From: Bryan Welsh <Bryan.Welsh@hertfordshire.gov.uk>
Sent: 24 June 2022 14:58
To: David Elmore
Cc: Matthew Armstrong
Subject: Ref: 6/2021/3172

**TOWN AND COUNTRY PLANNING ACT 1990
TOWN AND COUNTRY PLANNING (APPLICATION) REGULATIONS 1988**

Following an email from Highways dated 24/06/2022, regarding the above planning application we have examined the documentation provided and make the following comments:

DRAWING TITLE  
**Fire Tender Access Arrangements**

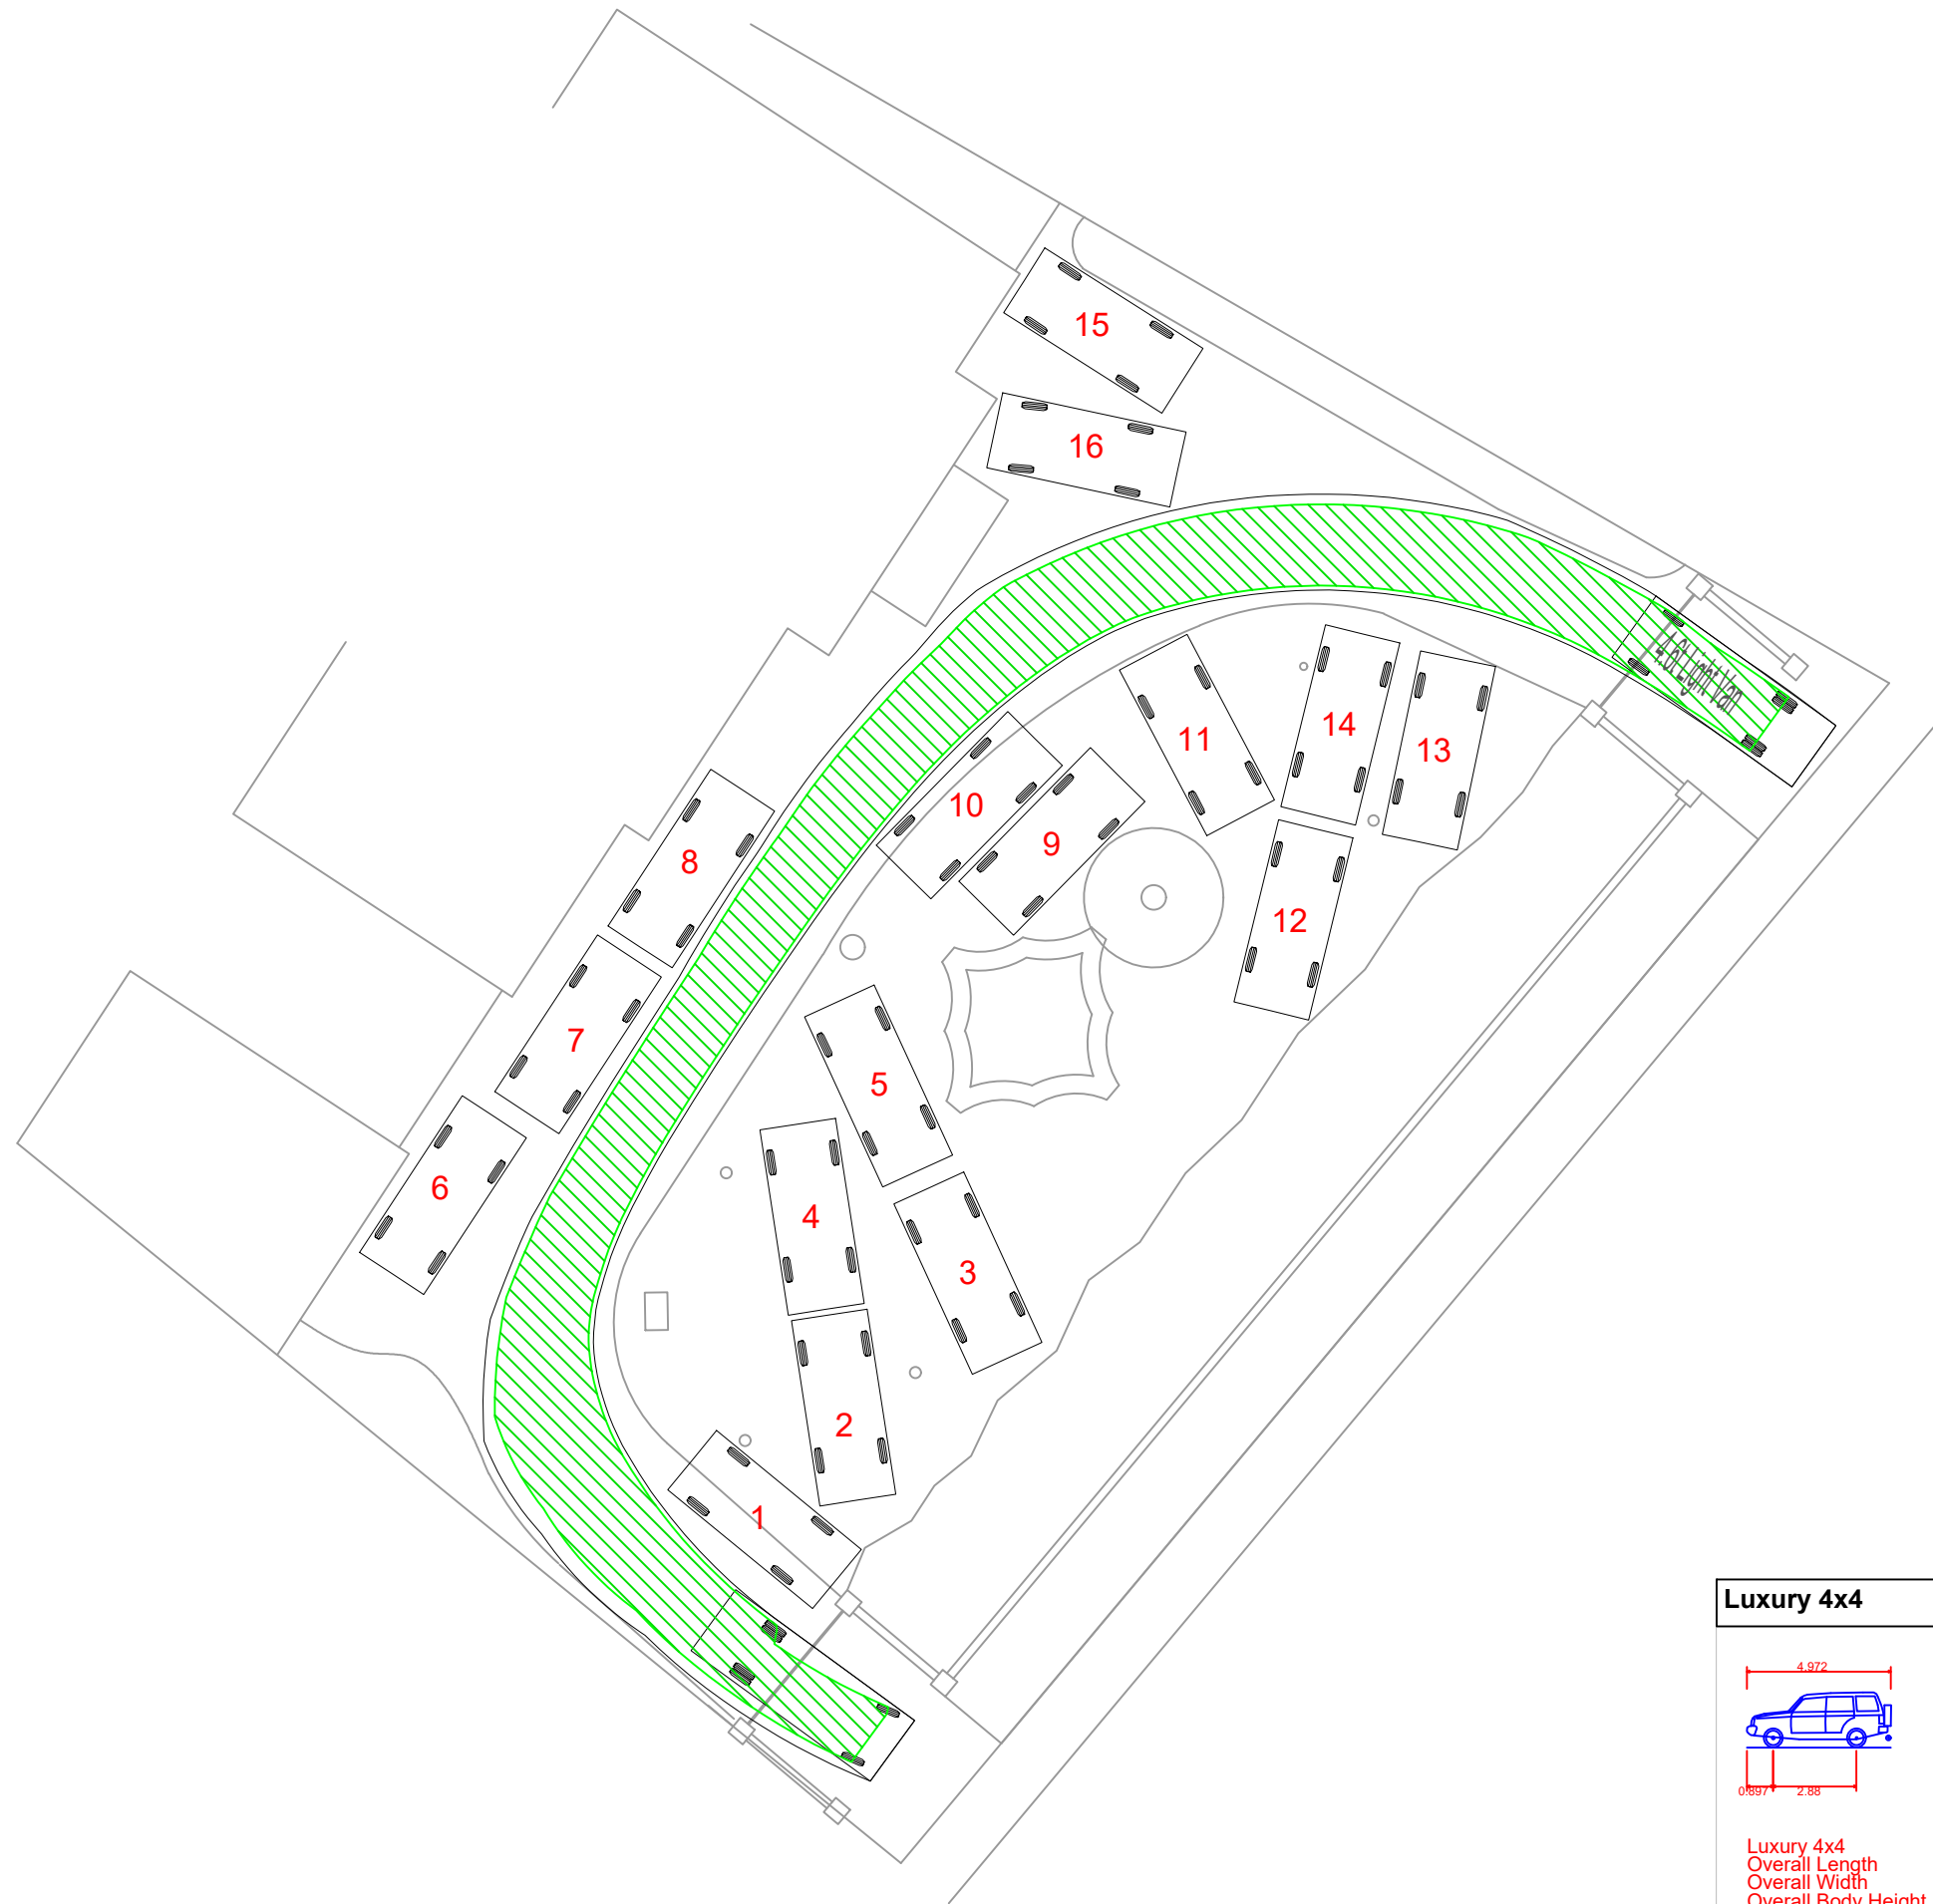
1. It appears that a fire appliance will be able to gain access to the driveway via the entrance gates, it should be ensured there is a minimum width between gateways of 3.1 meters. (Table 13.1)
2. It appears that from the parked position of a fire appliance on the driveway (as shown on document PTP-21092-005) to the furthest part of the building is within the required 45 meters from the rear of the appliance.
3. The 45 meter access rule only applies to buildings therefore activities that are carried out in the rear garden in open air are not restricted by fire service access requirements.
